DESIGN INTEGRITY PANEL RESPONSES

DESIGN INTEGRITY PANEL

**DRAWING NUMBER**  
**DA-0103**

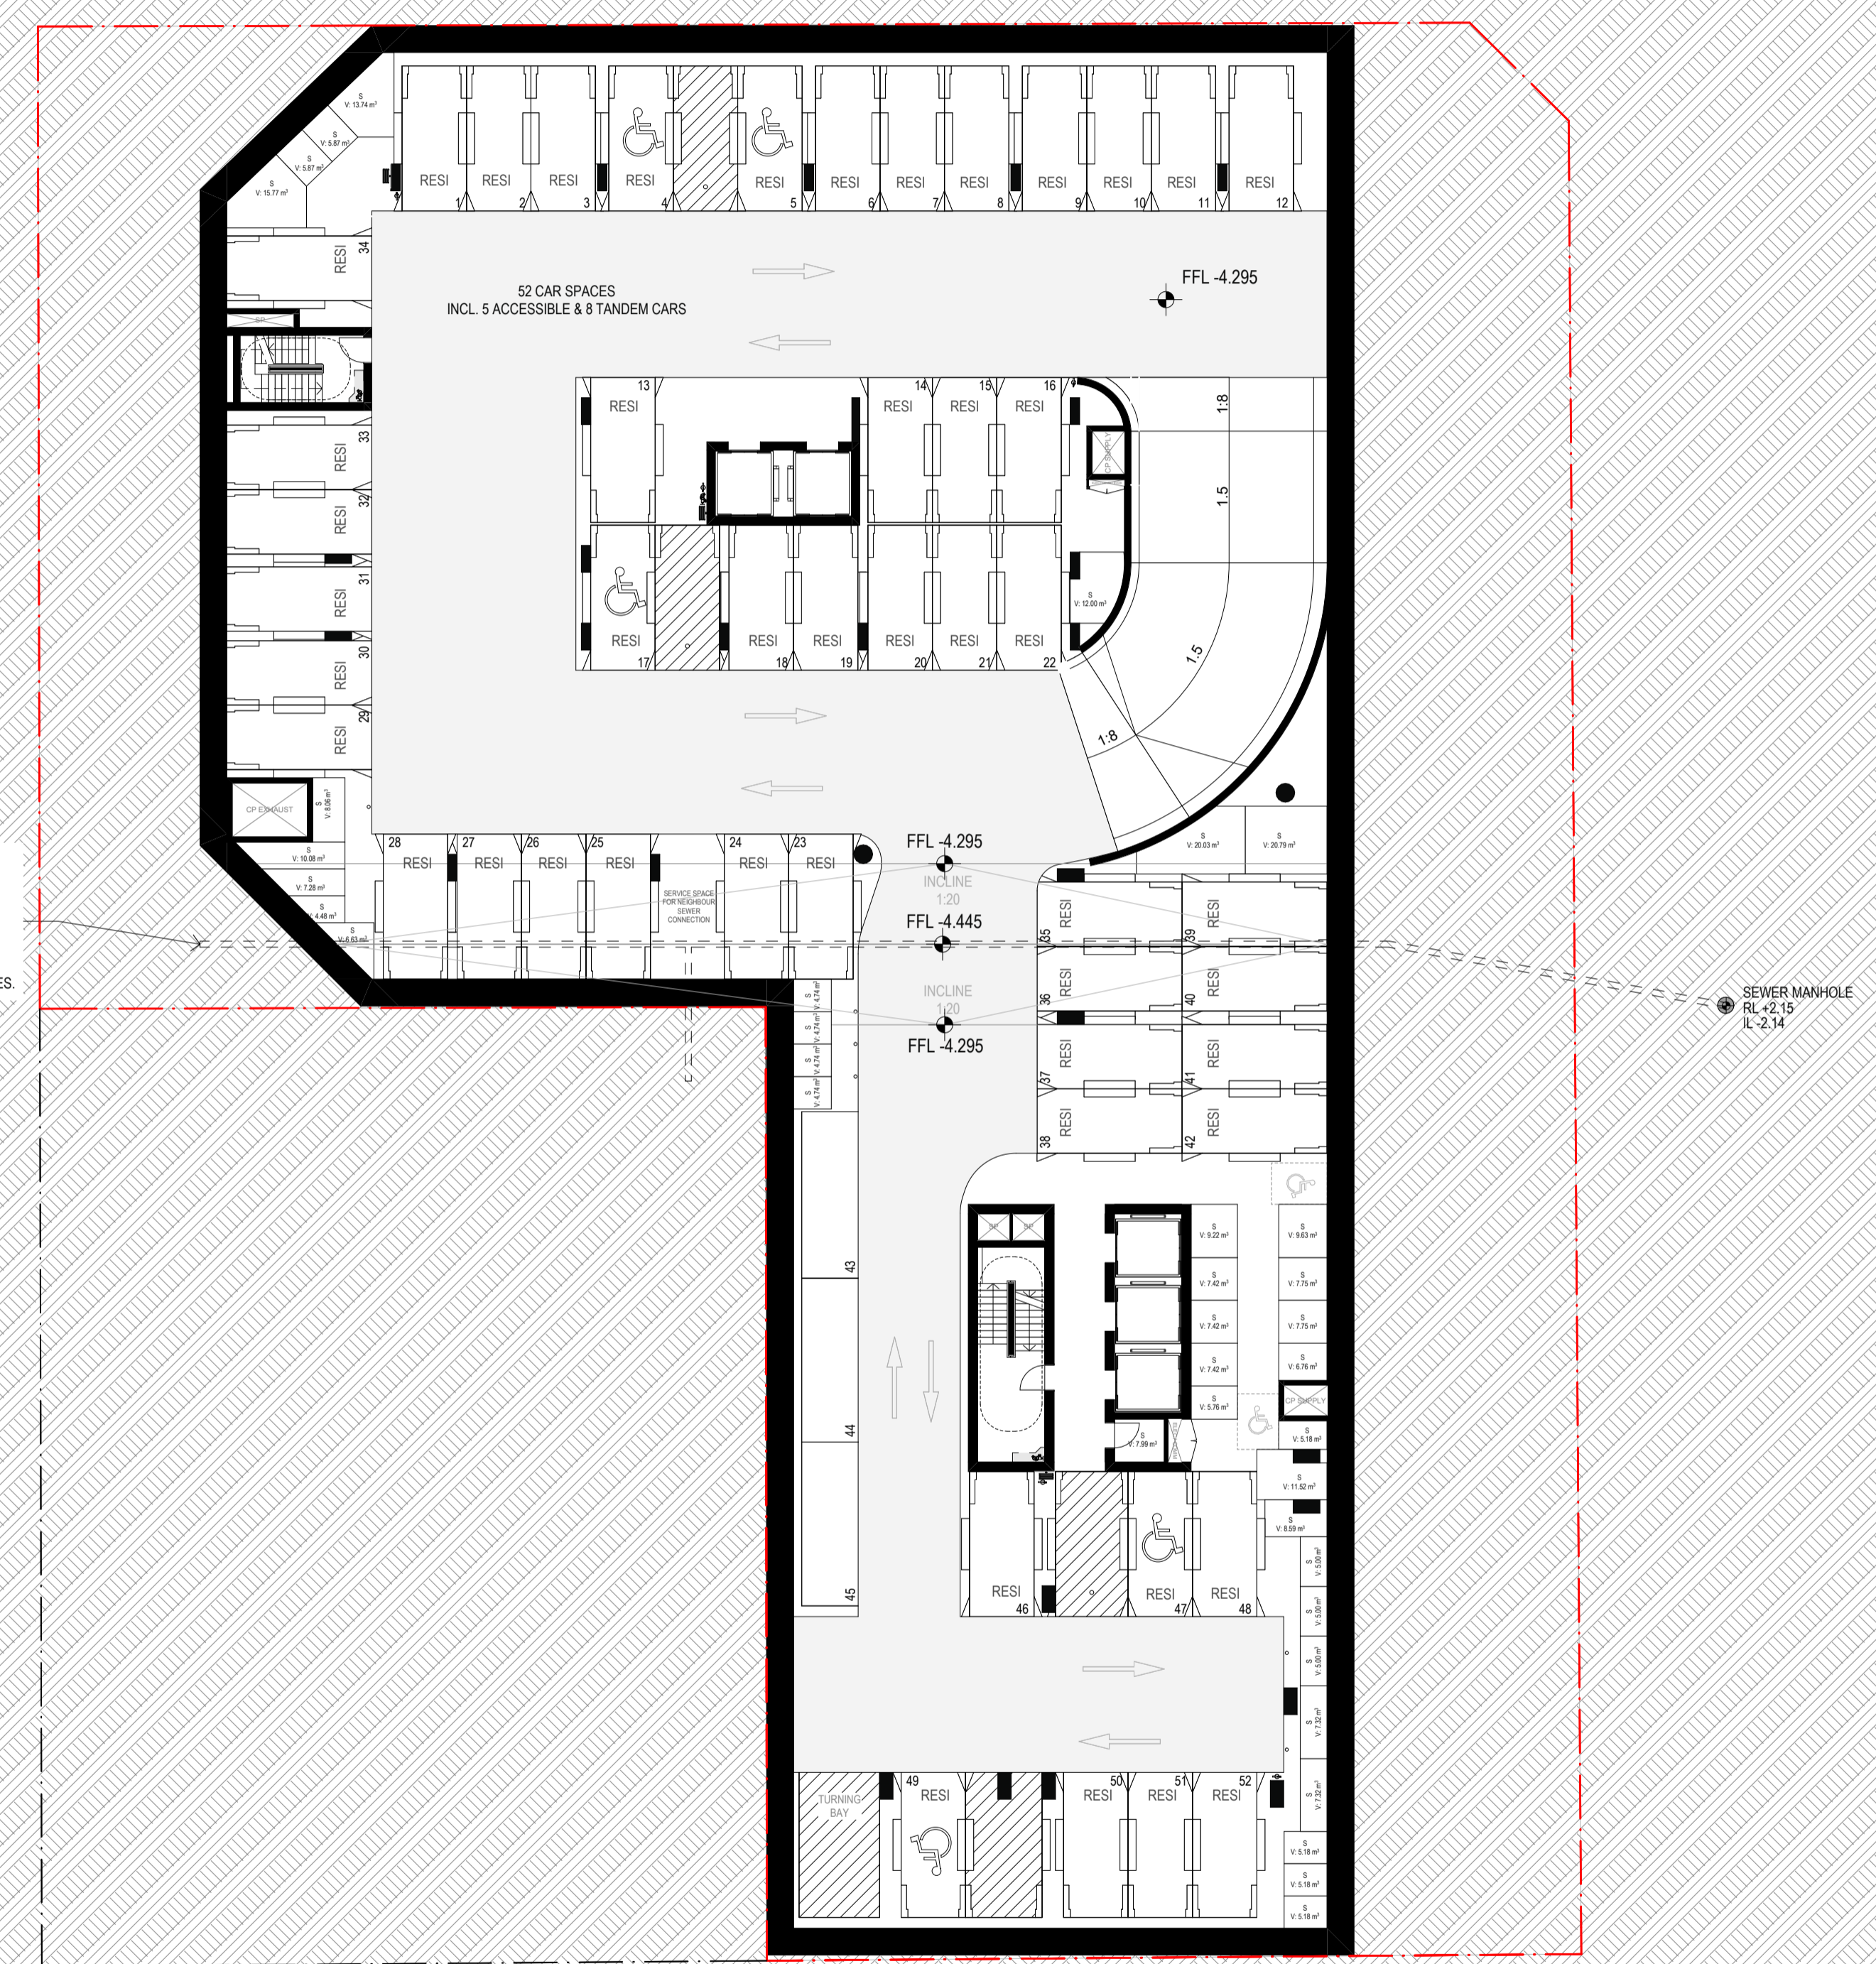
Further development of loading, basement and carparking design, and the treatment of underground sewer and stormwater infrastructure is required, ensuring alignment with technical objectives and constructability.

Improved Circulation: Basement layout reconfigured to enhance vehicle movement, efficiency, and access.

Loading Dock Relocation: Ground floor loading dock repositioned, prompting ramp relocation to Basement 1 for smoother entry and exit.

Optimised Car Parking: Clearer structural grid and simplified circulation improved legibility and reduced travel distances.

Reduced Tandem Spaces: Rationalised parking layout decreased tandem bays, improved safety and user convenience.

Setback Coordination: Minor encroachments within western setback allowed for diversion and upgrading of underground services.

DRAWING TITLE  
**ELEVATIONS - NORTH**

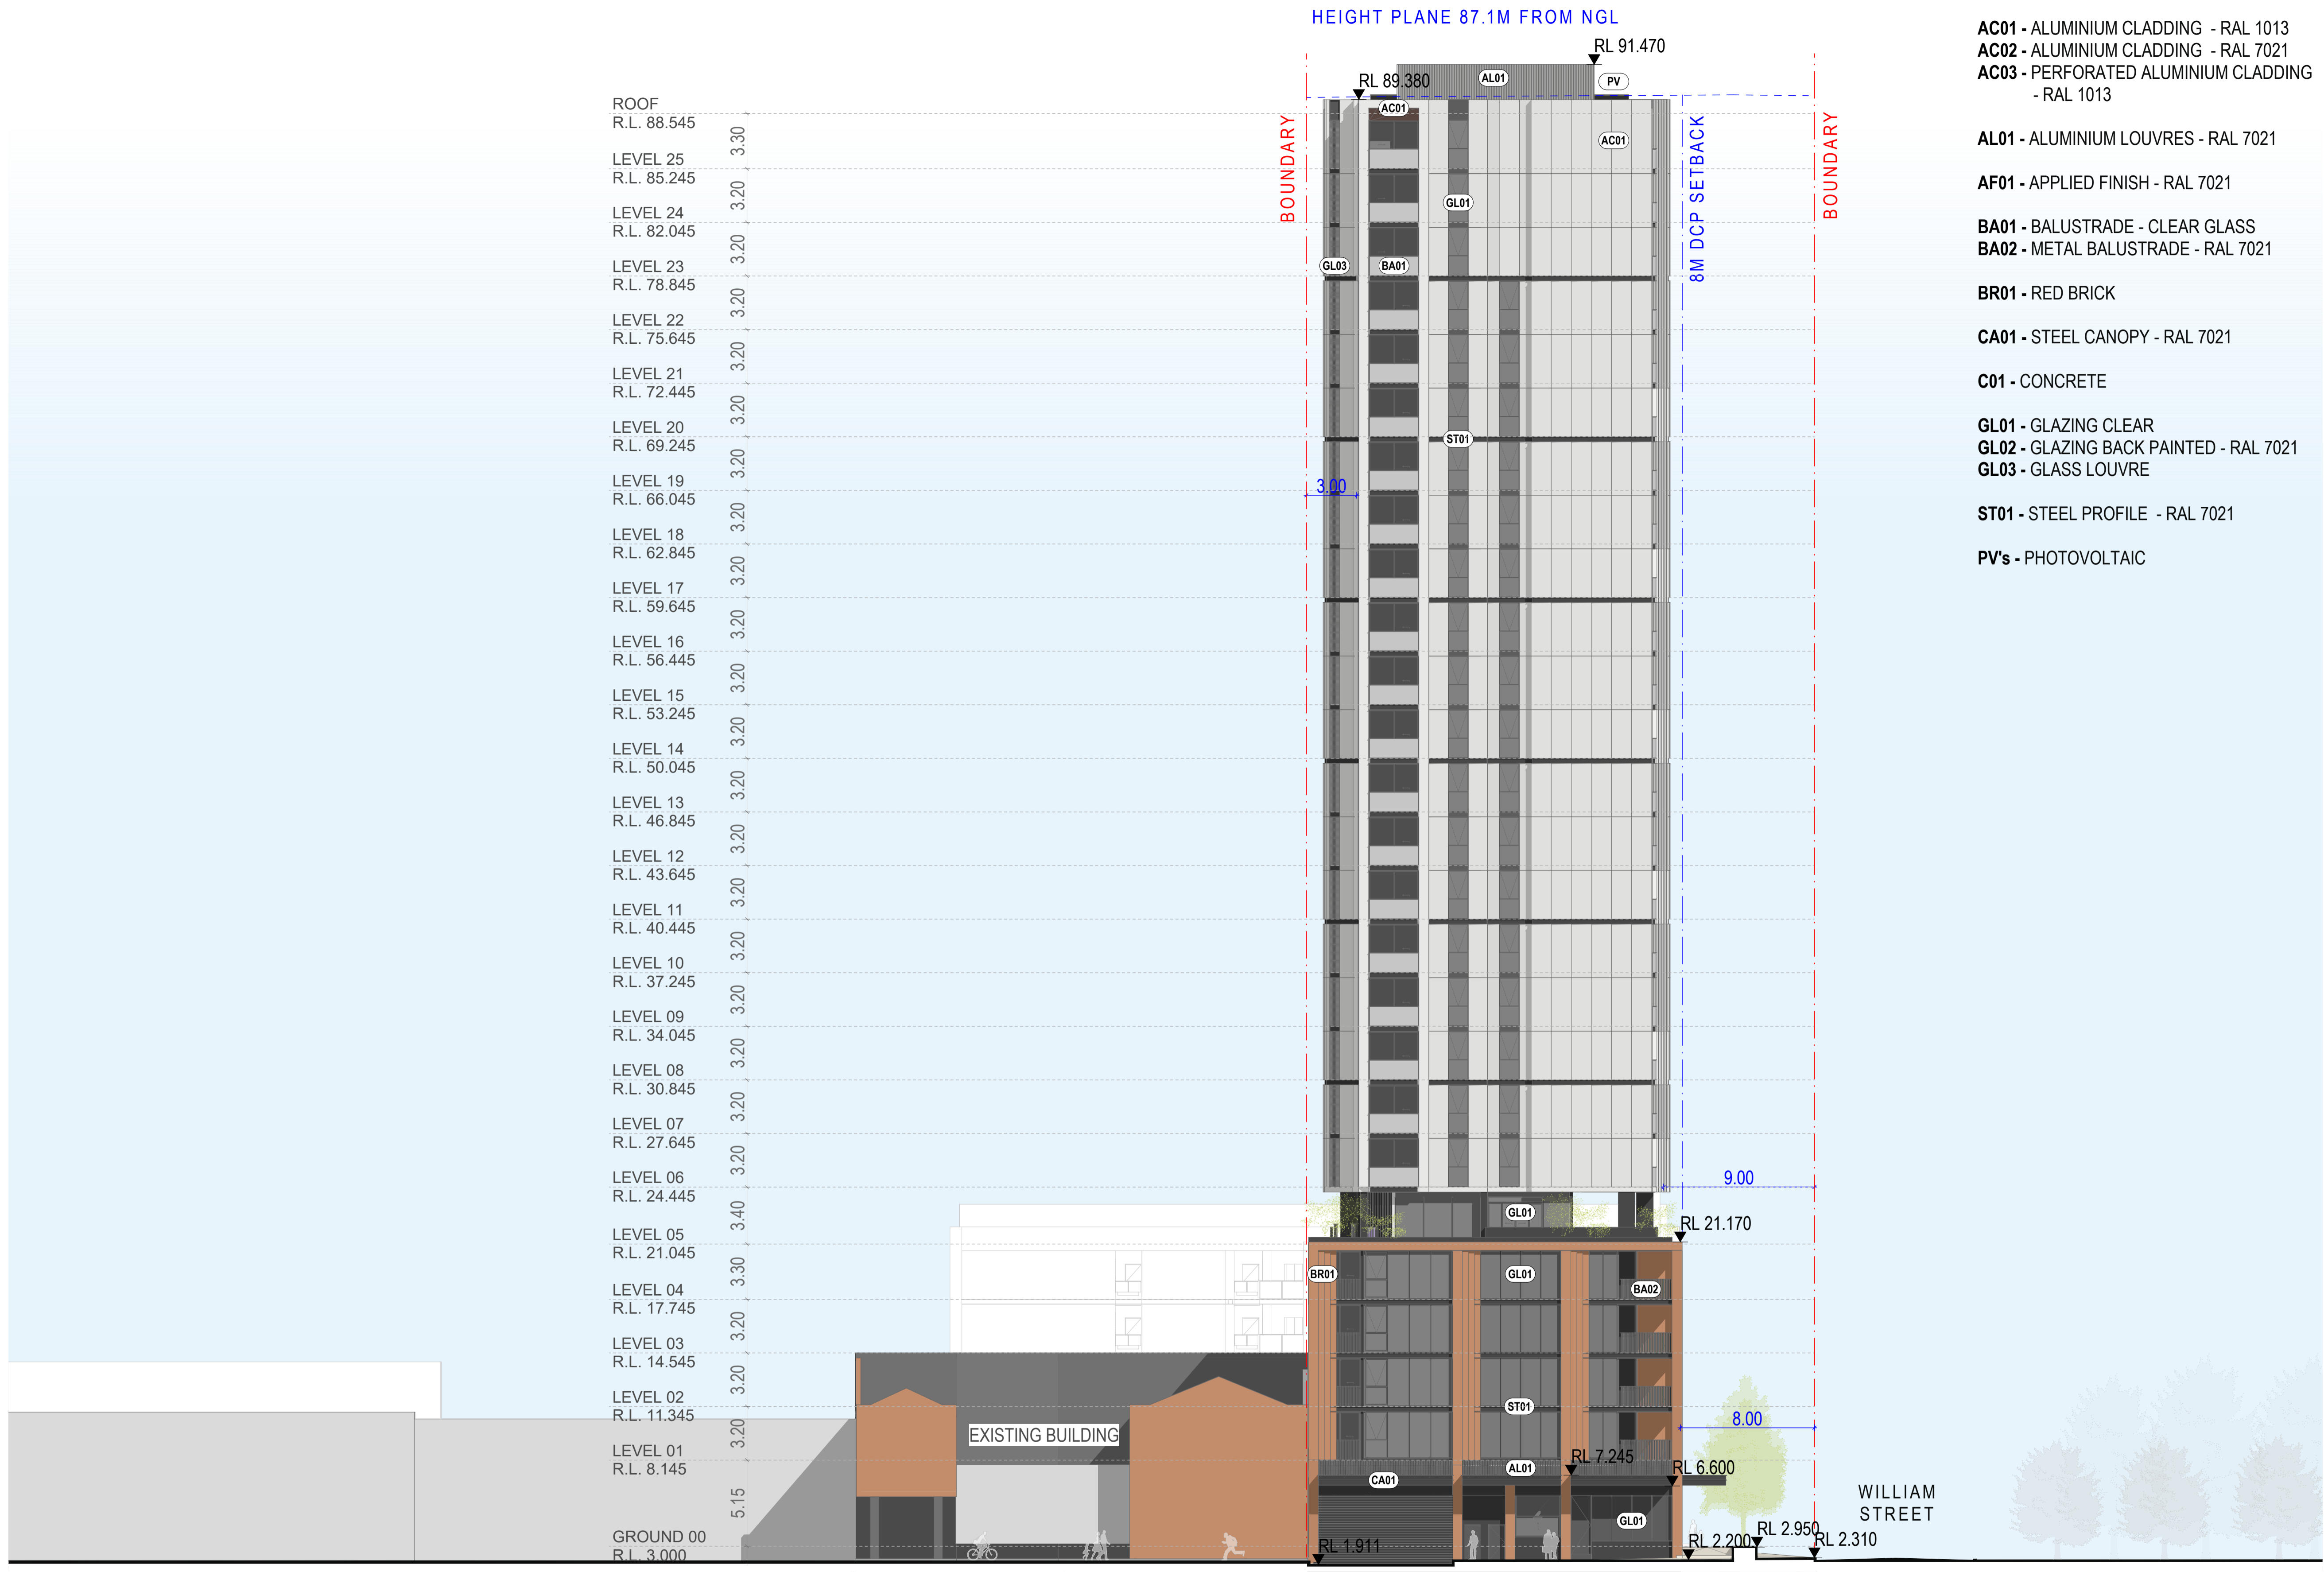
The northern elevation above the 2 storey street wall to Queens Road should be reconsidered to provide a more consistent podium materiality that would strengthen its relationship with the rest of the podium and street whilst creating opportunities for sun shading and articulation.

Refined Northern Podium: Enhanced material language and corner geometry for a stronger urban response and façade cohesion.

Stepped Corner Form: Re-sculpted podium corner improved geometric transition and unified the two building wings.

Material Palette: Two-level brick podium grounded the form, complemented by lighter upper elements to express verticality and reduce bulk.

Detailing Strategy: Varied brick coursing, reveals, and balcony treatments added depth and differentiation while maintaining material consistency.
